# **A1 in Northumberland: Morpeth to Ellingham**

**Scheme Number: TR010059**

## **Applicant's Response to Relevant Representations**

<b>Regulation Reference:</b>	APFP Regulation Rule 8(1)(c)
<b>Planning Inspectorate Scheme Reference</b>	TR010059
<b>Application Document Reference</b>	TR010059/6.7
<b>Author:</b>	A1 in Northumberland: Morpeth to Ellingham Project Team, Highways England

© Crown Copyright and Database Rights 2020 Ordnance Survey 100030649

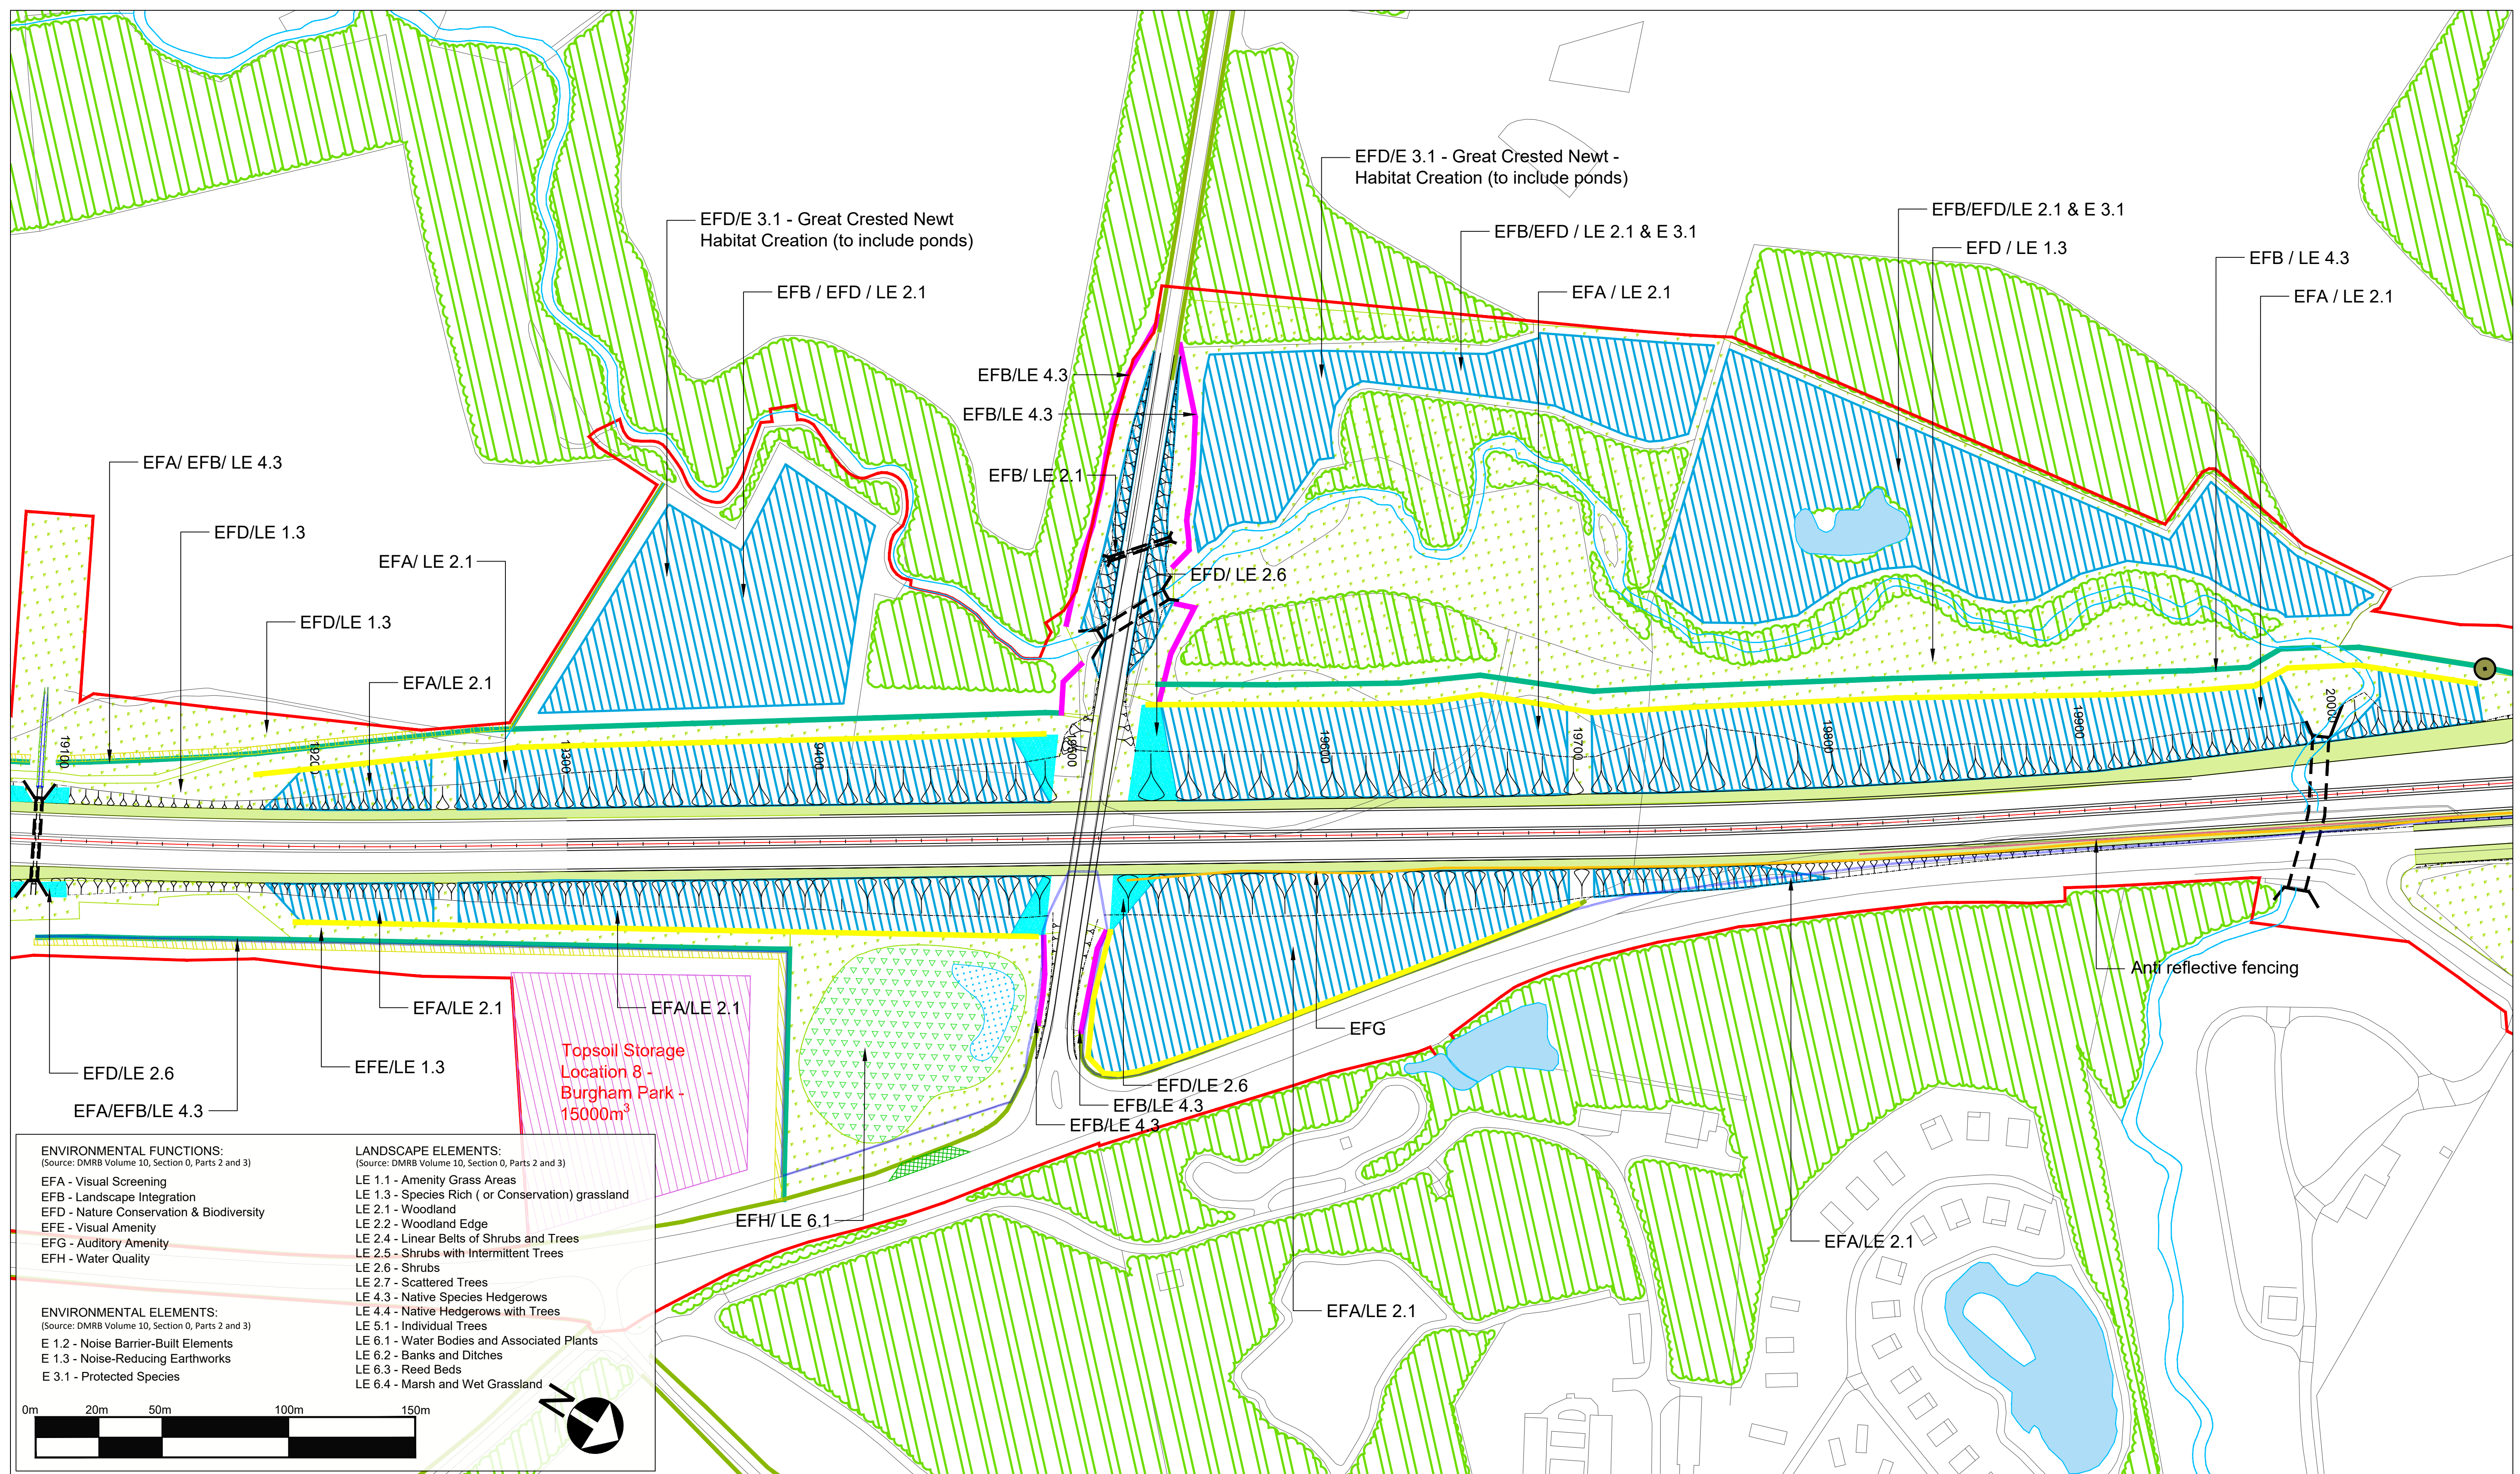
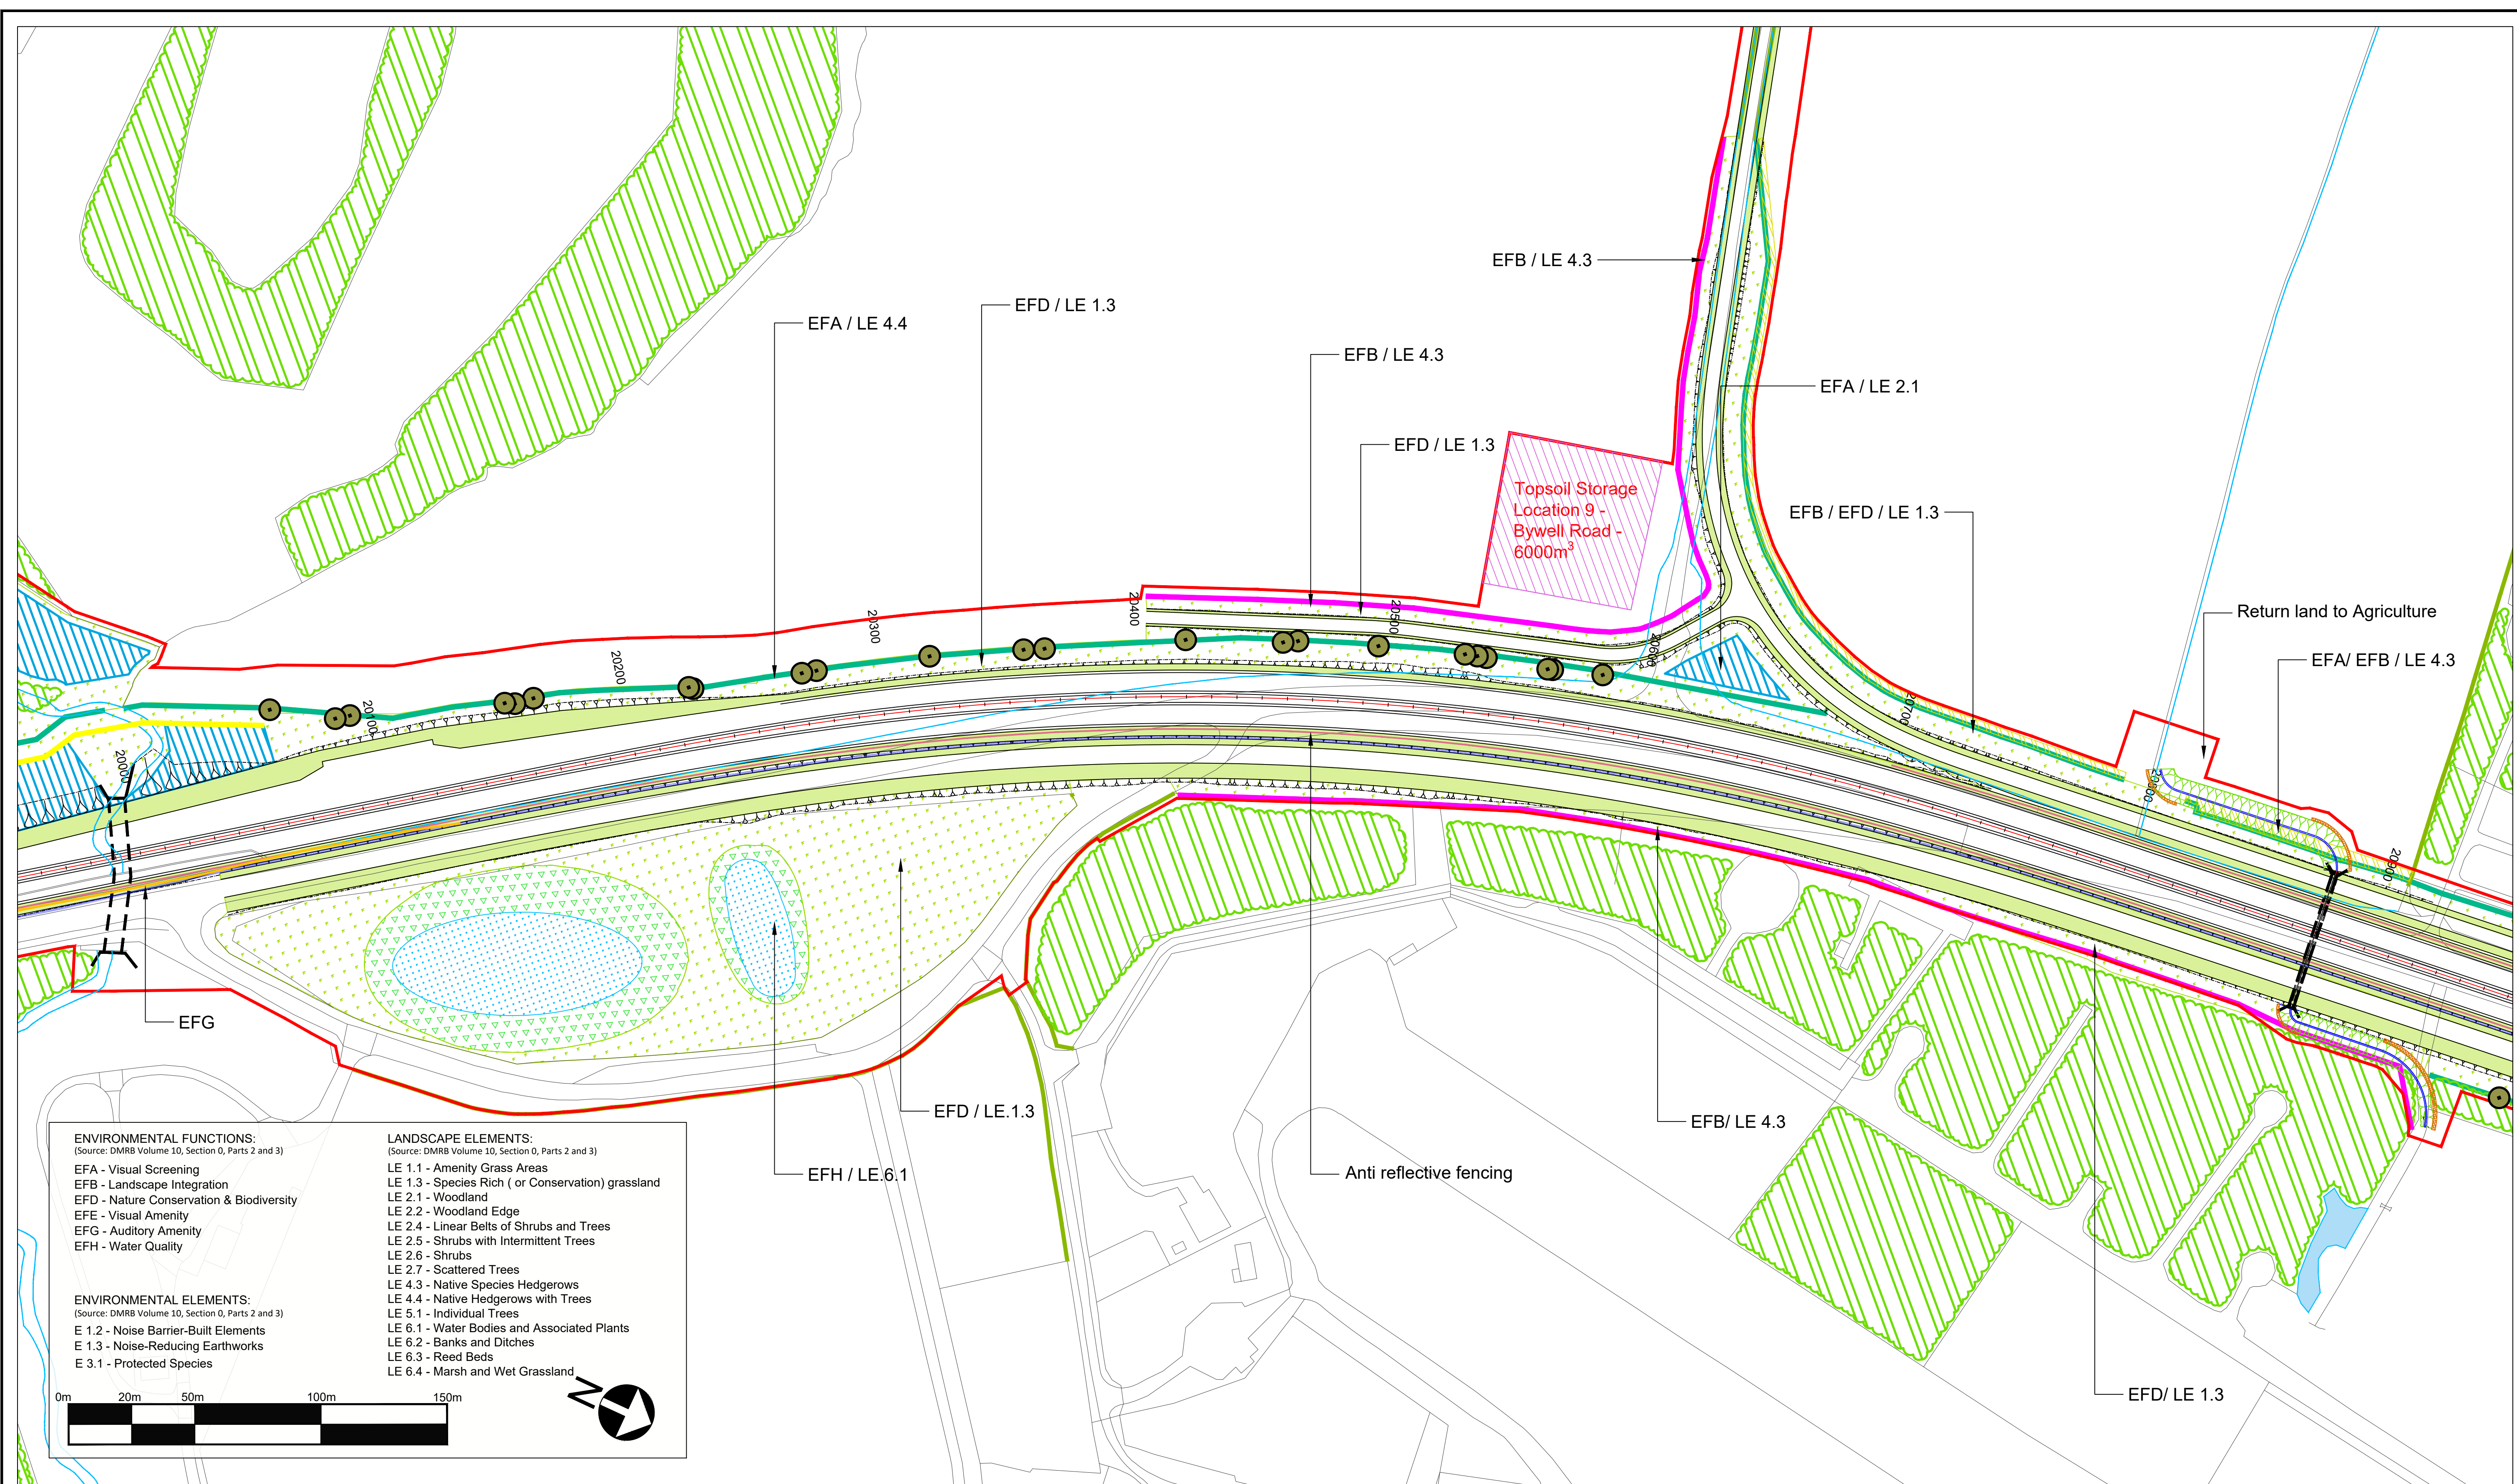
1.1.25	Mitigation for visual effects at Causey Park Bridge appear to be inadequate given the proposals include no vegetative screening for a 4.2m high embankment with a noise fence on top openly seen at a distance of 100-150m from the street and homes. The red line boundary includes an area where planting could have been included to provide some screening.	<ol style="list-style-type: none"> <li>1. The planting strategy associated with Causey Park Bridge does include an element of vegetative screening in the form of a hedge and groups of hedgerow trees that would replicate the existing vegetation to the west of Causey Park Bridge, reflecting the existing characteristics and interrupting views towards the Scheme. In establishing the landscape proposals as set out on Figure 7.8: Landscape Mitigation Masterplan Part A, [APP-095] the Applicant considered that provision of more extensive blocks of planting (trees and shrubs) or long linear belts of woodland, as suggested by NCC, would not be appropriate, as this would substantially change the characteristics and setting to the settlement. These are typically absent within the immediate area, and substantially increasing tree cover would change the open nature of the landscape to the west of Causey Park Bridge. The embankment and specifically the proposed noise barrier would be within the line of sight from receptors within Causey Park Bridge and are anticipated to screen traffic movements. However, despite this, it is anticipated that the effects on the receptors with west facing elevations would be significant during construction and in winter Yr 1, and would remain significant in the summer Yr 15.</li> <li>2. The negative visual effects arising on receptors forming the Causey Park Bridge community could be mitigated further through the adoption of further planting. However, taking the negative effects on landscape character that would arise as a result of the combination of the Scheme and the changes to the open characteristics of the landscape as a result of more extensive blocks of planting (trees and shrubs) or long linear belts of woodland, the proposed mitigation strategy, outlined in Figure 7.8:</li> </ol>

1.1.30	There is an ecological bias to the landscape design, both in narrative and in the resultant design. No information has been provided regarding species selection or management or	<ol style="list-style-type: none"> <li>1. The landscape design is not biased towards ecological mitigation but has sought to reflect the relationship between the different aspects of the assessment. The Applicant has developed the landscape and visual mitigation proposals, set out in Figure 7.8 Landscape Mitigation Masterplan Part</li> </ol>

Reference	Comment from Relevant Representation	Applicant's Response
		Landscape Mitigation Masterplan Part A, [APP-095] is the most appropriate option in terms of landscape character.

Reference	Comment from Relevant Representation	Applicant's Response
	consideration of this in terms of mitigation of landscape and visual effects.	<p>A [APP-095] and Figure 7.10 Landscape Mitigation Plan Part B [APP-144], to address where appropriate, the landscape and visual effects identified during the assessment. These proposals have been developed alongside the project ecologists, as there is a relationship between the landscape, visual and ecological effects arising as a result of the Scheme, and the provision of mitigation measures provided for landscape character or visual effects mitigation must also serve to provide sufficient replacement habitat.</p> <ol style="list-style-type: none"> <li>2. The Applicant has, within Section 7.9 Design, Mitigation and Enhancement Measures, of both Chapter 7: Landscape and Visual, Part A [APP-044] and Chapter 7: Landscape and Visual, Part B [APP-045], stated how embedded mitigation and specific mitigation measures to address landscape and visual effects should be incorporated into the detailed design.</li> <li>3. Issues of species selection would be addressed at the detailed design stage based on this requirement but would reflect the species found locally and would comprise native species, this is identified in:</li> <li>4. Part A: <ul style="list-style-type: none"> <li>• Paragraph 7.9.14, item c, native tree and shrub species would be in keeping with local landscape character</li> </ul> </li> <li>5. Part B: <ul style="list-style-type: none"> <li>• Paragraph 7.9.4, item c, the incorporation of species rich hedgerows</li> <li>• Paragraph 7.9.13, items b and f, the incorporation of native species in keeping with the local landscape character.</li> </ul> </li> <li>6. Depending upon the species selected and the final design of the measures to deliver mitigation, the management of the mitigation features would be included within a landscape scheme to be approved by the SoS following consultation with NCC, as part of Schedule 2, Requirement 5 of the draft DCO. These measures are secured within the items S-L1 – S-L5, S-L9 of Table 3-1 - Register of Environmental Actions and Commitments: The Scheme, in the Outline CEMP [APP-346]. Mitigation measures would be monitored during the establishment period to ensure their delivery through items S-L11 – S-L13 of the same document.</li> <li>7. In addition, the Outline CEMP [APP-346], prepared and updated through the design and delivery phases would be subsequently converted to a Handover Environmental Management Plan (HEMP) to secure the long-term establishment of the mitigation measures required by the Scheme. Mitigation measures would be monitored during the establishment period to ensure their delivery through items S-L11 – S-L13 of the same document.</li> </ol>
